ALTERATIONS TO ELEVATIONS FROM PREVIOUS
PLANNING APPROVAL 3/2010/0721

RE: Alterations to elevations from previous planning approval 3/2010/0721
AT: 91 Berry Lane, Longridge

RE: WORKS AT 91 BERRY LANE, LONGRIDGE

REAR (SW) ELEVATION

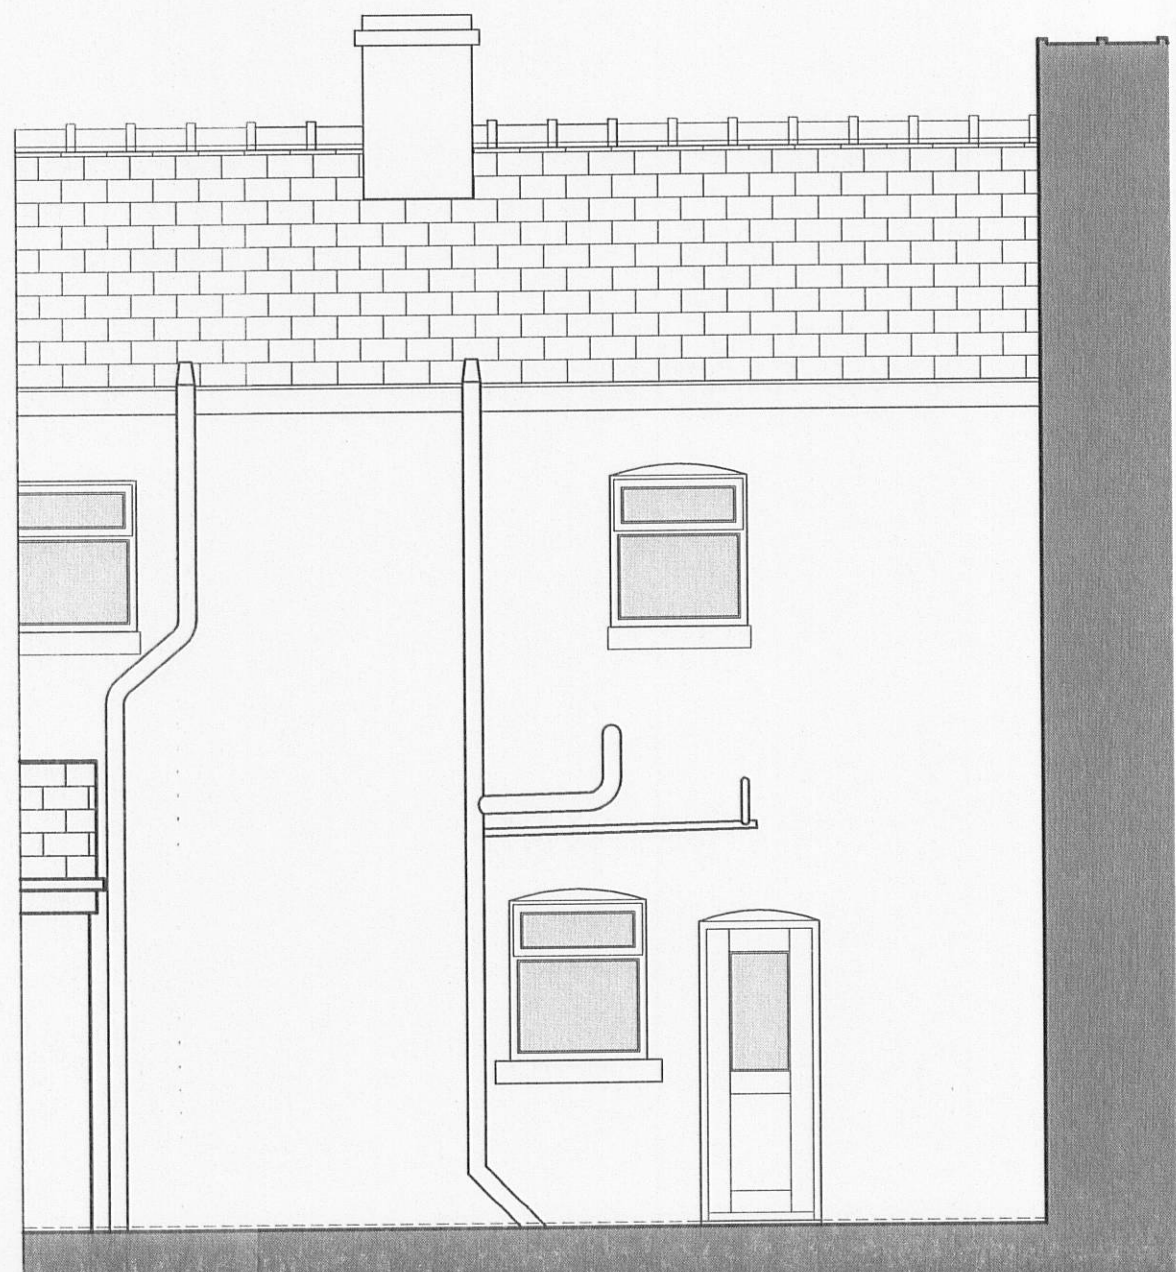
- Please can you show the property boundary line on the rear elevation as you have done on the front elevation. It would be useful to also show this on the floor plans. Also, please can you show the existing door on the rear elevation of the adjoining property 93 Berry Lane.

Will email you revised drawing end of the week
